**Subject:** RE: AB/54/22/DOC

However, it is clear from the response provided by the applicant that two of the consultation comments (1 and 4) have not been satisfactorily addressed. **On this basis I recommend that the application is refused.** It is suggested

SURFACE WATER DRAINAGE PLAN
SCALE 1:200

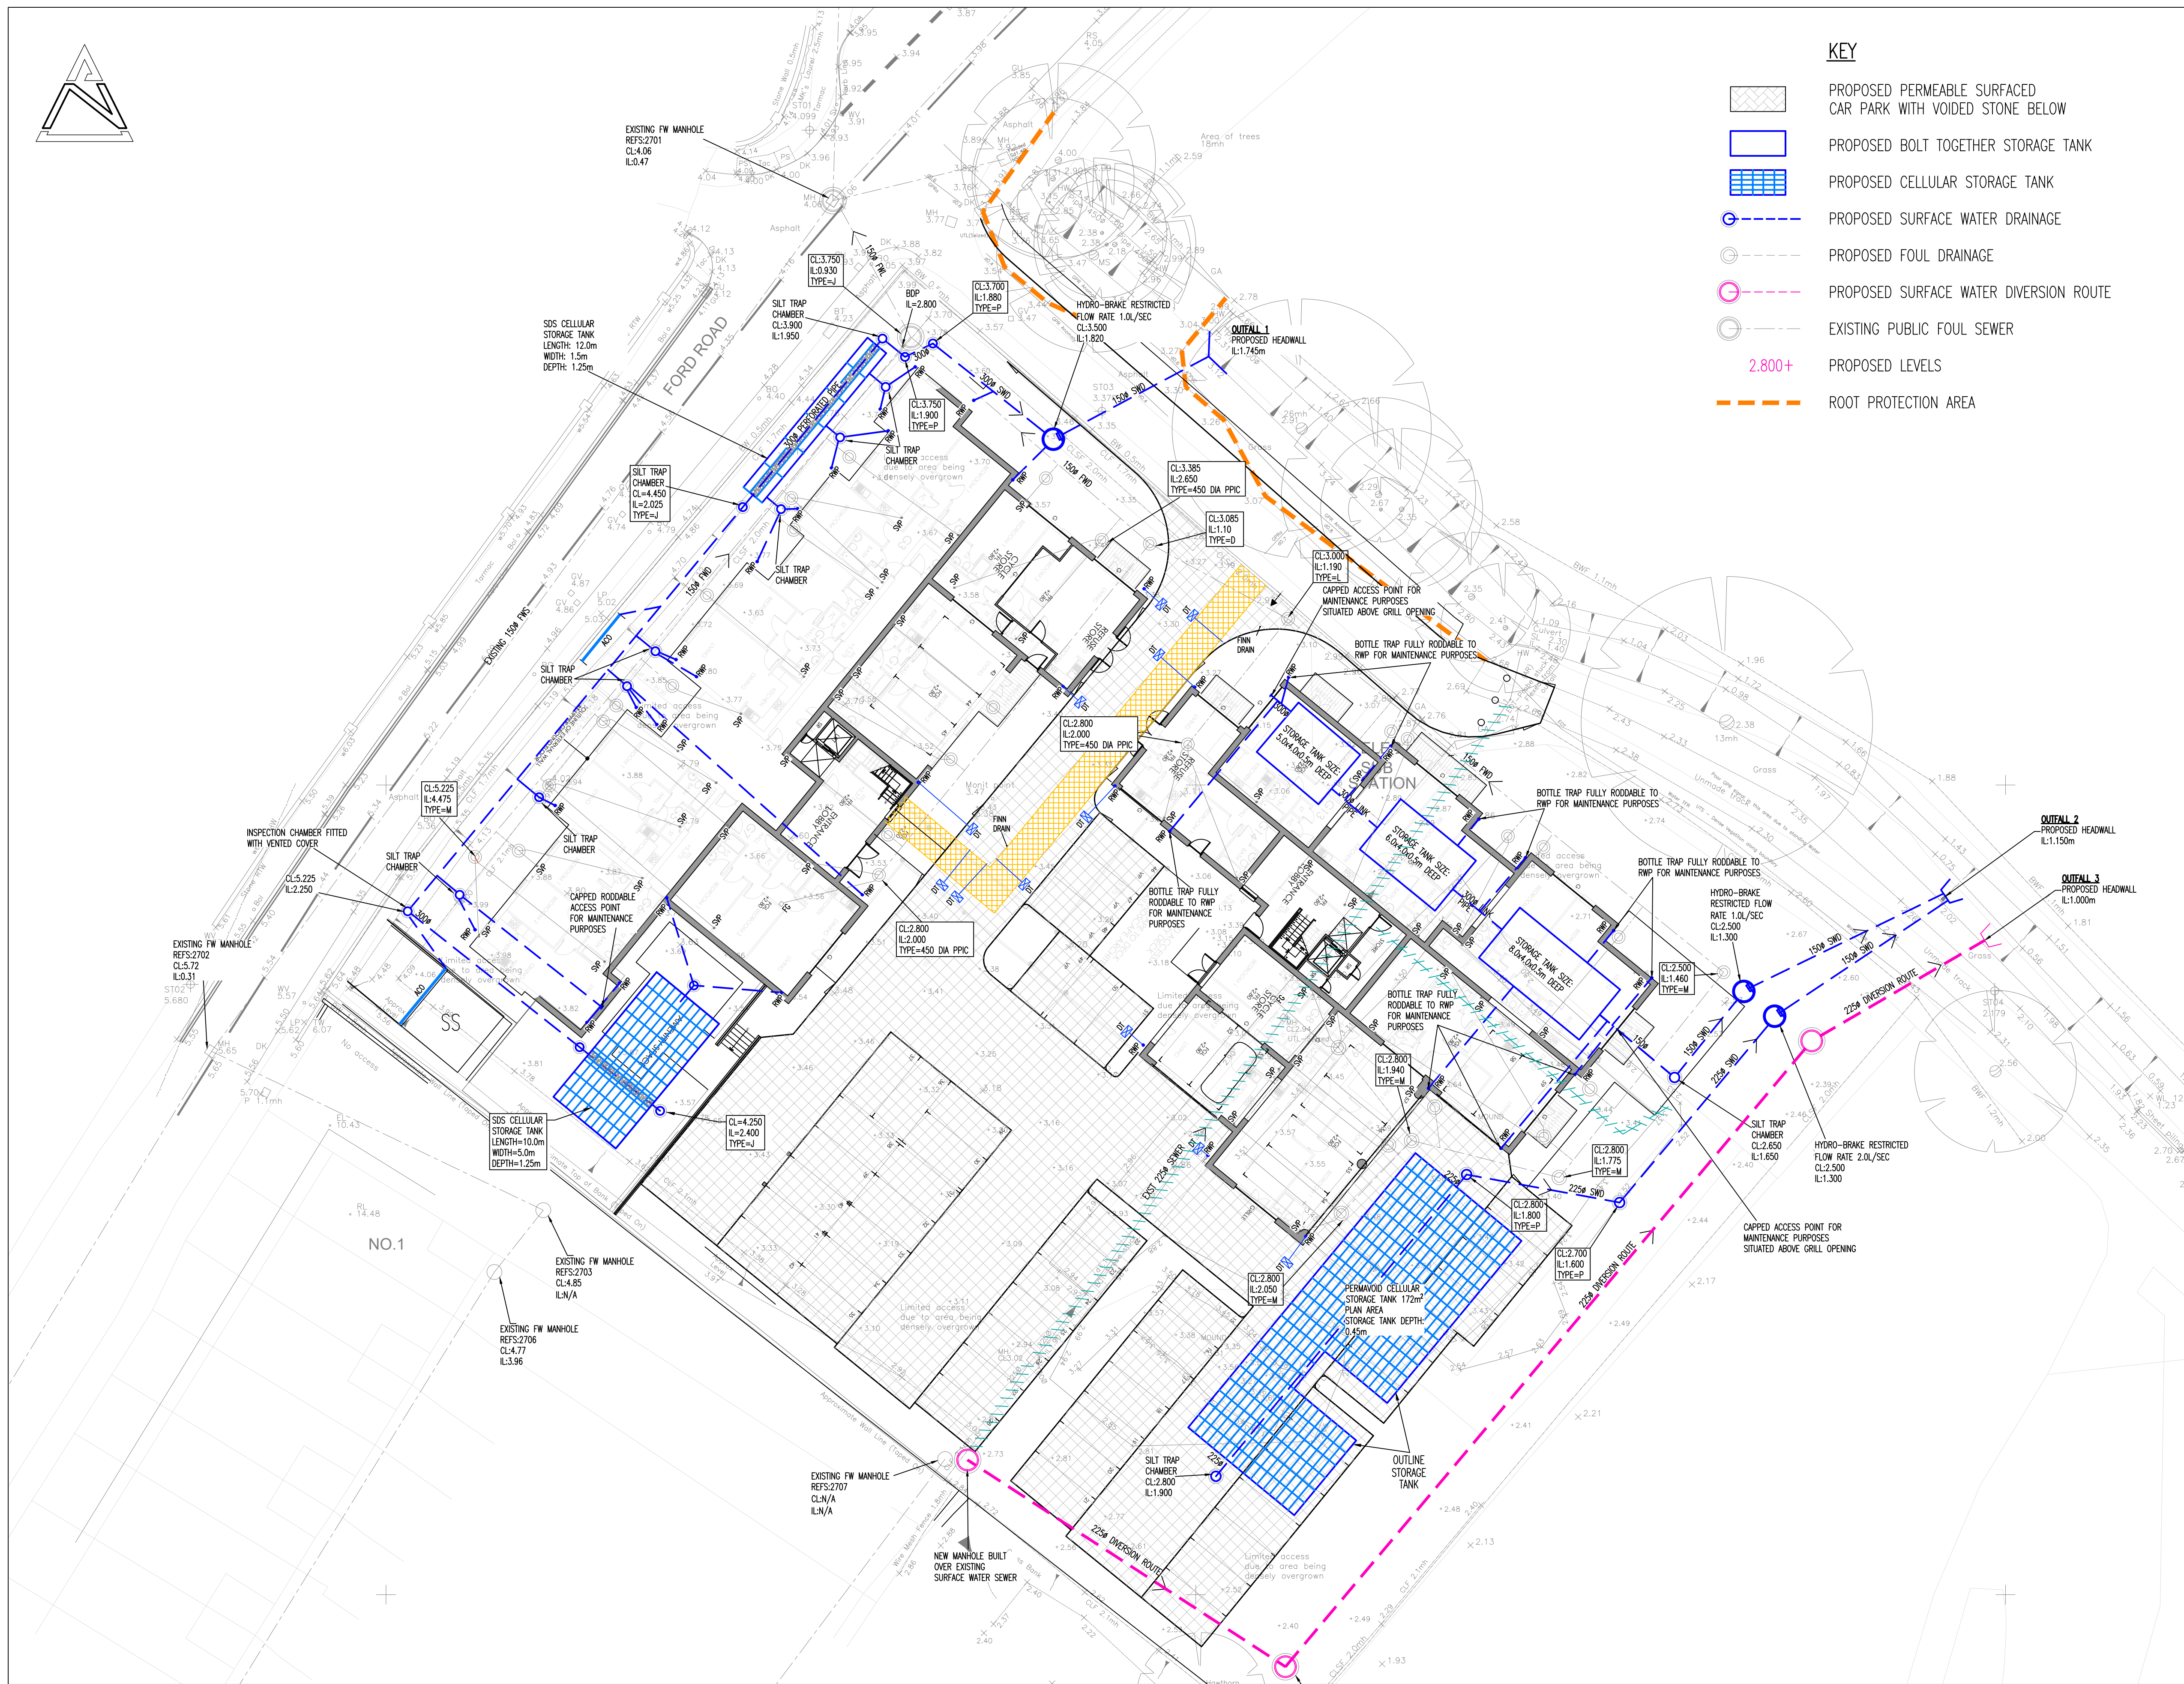
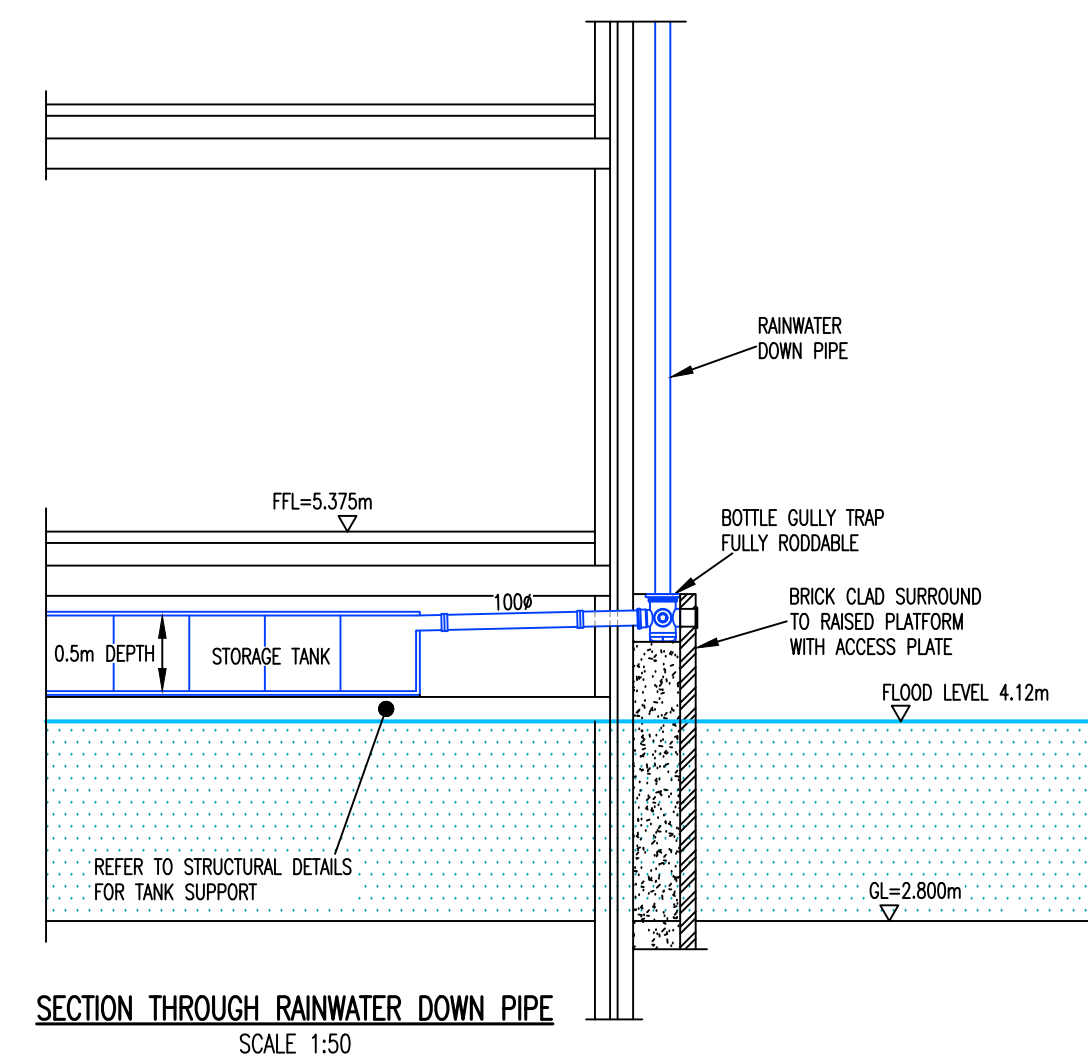
1. Insufficient information has been provided regarding the design of the suspended above ground tank.

We require full design drawings for this feature including details of its construction, including but not limited to:

- Details of the materials used to make the tank
- Details of any welding or riveting
- Details of any galvanising
- Details of any seals or joints
- Details of any expansion joints (if required) and calculations confirming whether this will be necessary.

- Details of the support mechanism (we appreciate this has been submitted under different application, but this will be required in this application also)

- We also require signoff on the design for the tank from your structural engineer.  
This signoff must show that the engineer has considered the impacts of higher than design flood levels on the drainage system's buoyancy or the impact that the drainage system becoming buoyant would have on the building above.

- Signoff of the tank from the manufacturer.
- Confirmation from the manufacturer that the tank will be fully watertight.
- Details of the access arrangements for maintenance and inspection, including detailed drawings of any maintenance hatches.

- Details of any confined space signage.
- Details of any foul air prevention systems (if required).
- Details of the openings in the grills to permit entry for maintenance access.

- Buoyancy calculations to confirm the tank will not damage the building in the event flood levels are at a reasonable worst-case level.

The order for the suspended above ground tanks is yet to be placed. Therefore the construction details are not available. The tanks design / fabrication details sign off will follow when technically confirmed. Full details will be in the O & M manual issued to the management company.

*This is not acceptable. The condition states that full details of the surface water drainage design will be agreed via this condition and the tanks are fundamental and critical elements of the design. We expect all of the details listed by our consultant to be included in the next DOC submission.*
